Our Ref: C25/686

Re: **Birriwa Solar Farm (SSD-29508870 Mod-1)**

Birriwa Solar and BESS Project
Amendment Report
Noise and Vibration Impact Assessment Addendum
Figure 1.2

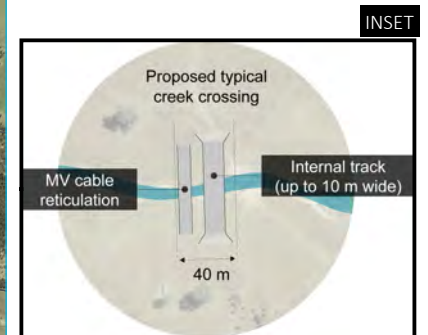
The design of the potential creek crossings or Proposed Typical Creek Crossing (including internal tracks and MV cables) should be in accordance with the document *Why do Fish Need to Cross the Road? Fish Passage Requirements for Waterway Crossings (NSW Fisheries 2003)* and the *Policy and Guidelines for Fish Habitat Conservation and Management (Update 2013)*.
